DEVIATION REQUEST AND DECISION FORM

Project Name :	Crossroads North
Schedule No.(s) :	5408001008, 5408001029, 5408001032, 5408001033, 5408001034, 5408001041, 5408001042, 5408001050, 5408001051, 5408001052
Legal Description :	LOTS 12, 13, 14, 15, 16 AND 18, HILLCREST ACRES, ACCORDING TO THE PLAT THEREOF RECORDED MAY 12, 1960 AT RECEPTION NO. 153860, EXCEPT THAT PORTION ACQUIRED BY THE DEPARTMENT OF TRANSPORTATION, STATE OF COLORADO AS DESCRIBED IN RULE AND ORDER RECORDED APRIL 28, 2004 UNDER RECEPTION NO. 204068322, AND EXCEPT THOSE PORTIONS CONVEYED TO EL PASO COUNTY BY AND THROUGH THE BOARD OF COUNTY COMMISSIONERS OF EL PASO COUNTY, COLORADO BY SPECIAL WARRANTY DEED RECORDED DECEMBER 17, 2014 AT RECEPTION NO. 214116021 AND RECORDED DECEMBER 17, 2014 AT RECEPTION NO. 214116022, COUNTY OF EL PASO, STATE OF COLORADO. LOT 17, HILLCREST ACRES, COUNTY OF EL PASO, STATE OF COLORADO, EXCEPT THAT PORTION CONVEYED TO EL PASO COUNTY BY AND THROUGH THE BOARD OF COUNTY COMMISSIONERS OF EL PASO COUNTY, COLORADO BY SPECIAL WARRANTY DEED RECORDED DECEMBER 30, 2014 AT RECEPTION NO. 214119767. LOT 19, HILLCREST ACRES, COUNTY OF EL PASO, STATE OF COLORADO, AS AMENDED BY SURVEYOR'S STATEMENT RECORDE

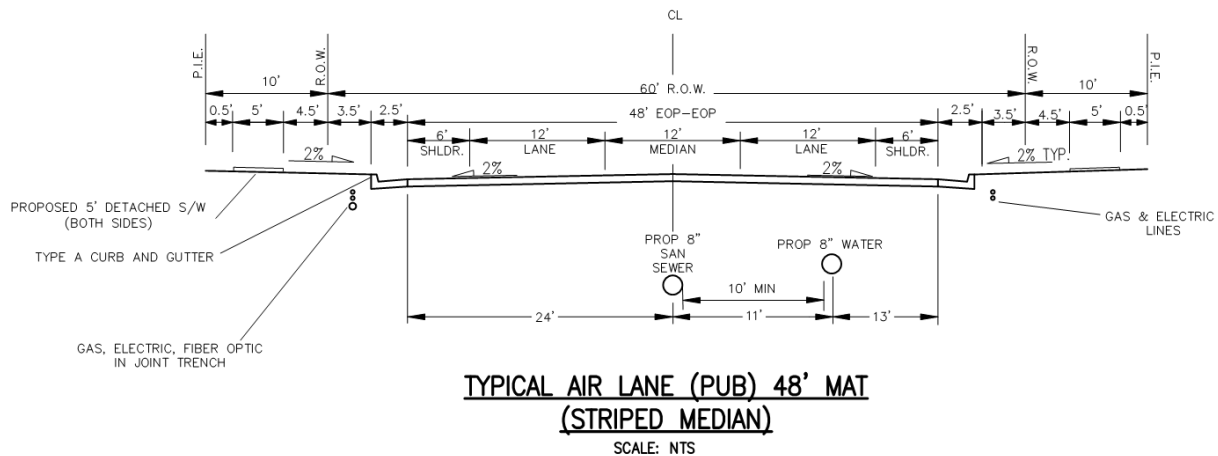
Revise. Air Lane is a public road. Unresolved.

Revise to Chapter 2 Table 2-7 and Appendix F SD_2-4
Unresolved

THIS HAS BEEN REVISED TO "PUBLIC ROAD".

Γ	THESE STANDARDS HAVE BEEN REVISED TO CHAPTER 2 TABLE 2-7 AND APPENDIX F, SD_2-4	Γ
L		┘

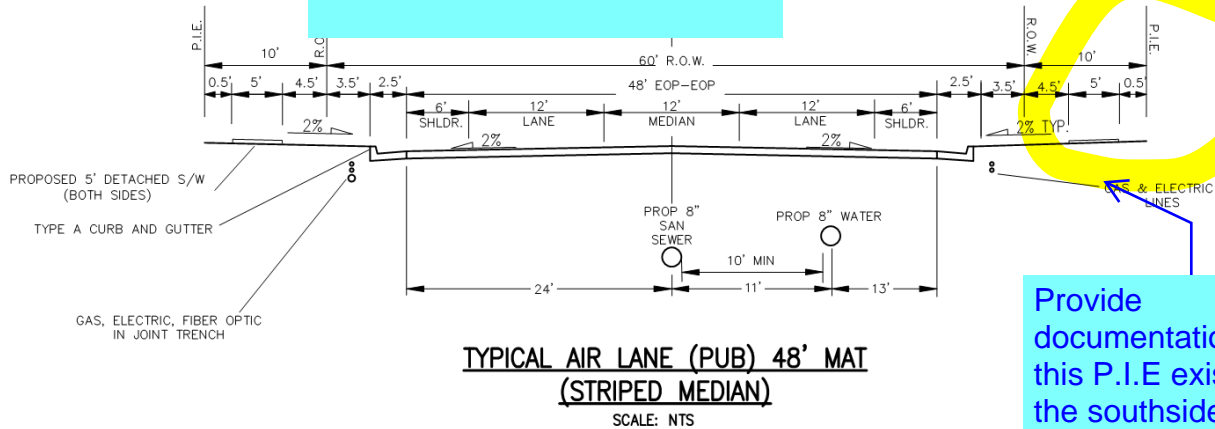
Revise. Air Lane is public road. Unresolved

Include Parking is not permitted. No change. Unresolved

Provide documentation that this P.I.E exist along the southside of Air Lane. If it doesn't then the development would need to acquire the necessary easement from the property before the deviation request would be approved.

Plat 1950 (attached) for Hillcrest Acres subdivision does not show this easement. Unresolved.

THIS HAS BEEN REVISED TO "PUBLIC ROAD".

THIS STATEMENT HAS BEEN ADDED TO THE BULLET POINT

AN EXPLANATION WITHIN A NEW BULLET POINT HAS BEEN ADDED TO ADDRESS THIS.
